Re: Verona, Paddington

SUBJECT PREMISES – 13-17 Oxford Street & 2 Verona Street, Paddington

RE: Verona Paddington: Response to Acoustic RFI's

## Appendix B **Alternative Ventilation Markup**

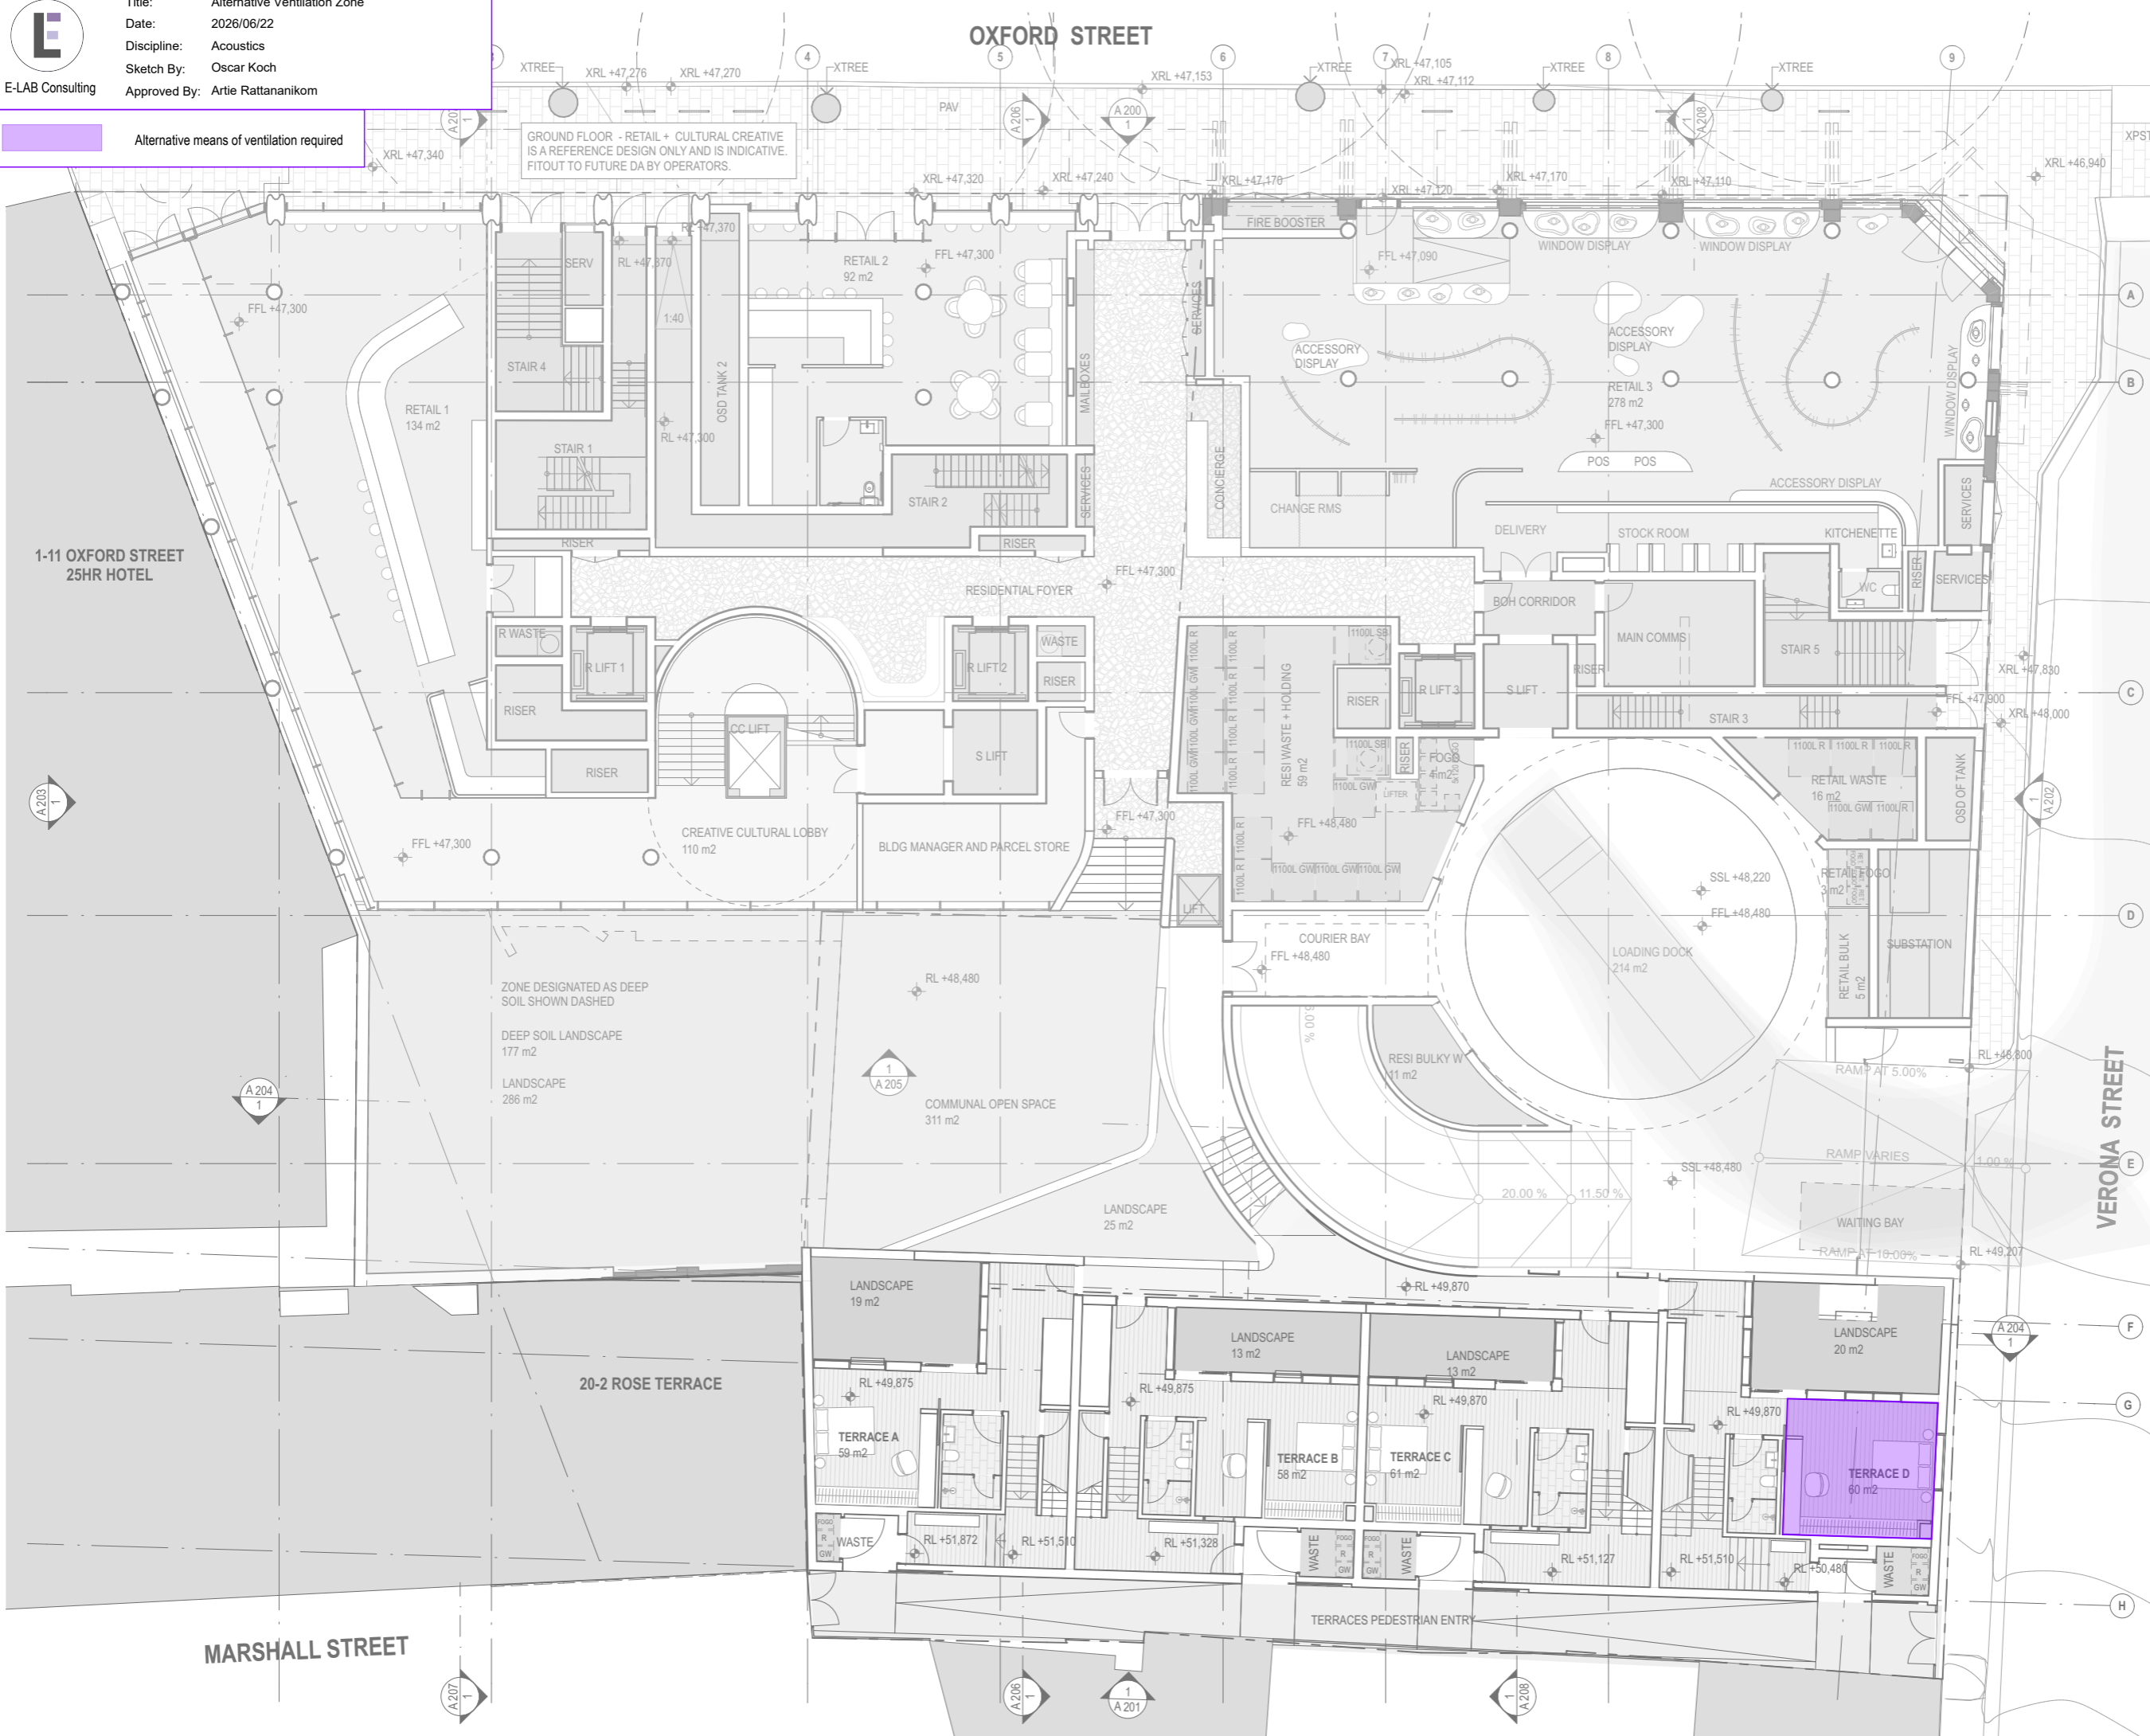
AGENCY	RFI COMMENTS	RESPONSE TO RFI
City of Sydney	<p><u><i>Amended Noise and Vibration Impact Assessment report</i></u></p> <p><i>It is noted that the detailed façade performance matrix that previously linked façade noise levels and glazing areas to specific acoustic requirements has been deleted from Section 9.3 (traffic noise intrusion) of the amended Noise and Vibration Impact Assessment report.</i></p> <p><i>The revised approach reduces clarity on how internal noise criteria will be achieved and shifts the detailed design to later stages. It also represents a reduction in the nominated acoustic façade performance compared to the previous report. These details should be reinstated within any approved Noise and Vibration Impact Assessment to demonstrate that the proposed façade treatments will achieve the relevant internal noise criteria under worst-case traffic noise conditions.</i></p>	<p>A detailed mark-up of façade glazing to all habitable spaces has been provided in Appendix C of the NVIA, applicable to the current design. The façade performance matrix was removed from the report as it did not provide any additional information relative to the current scheme. The current approach suitably demonstrates a compliant strategy for glazing to all habitable spaces within the development.</p> <p>Any changes in glazing area from the current design shall be reviewed during detailed design stages of the development.</p> <p>The reduction in the nominated acoustic façade performance was made as a correction (previous increased values were a typographical error), and now correctly correspond to the equivalent glazing build-ups (which have not changed since the last revision of the NVIA).</p>
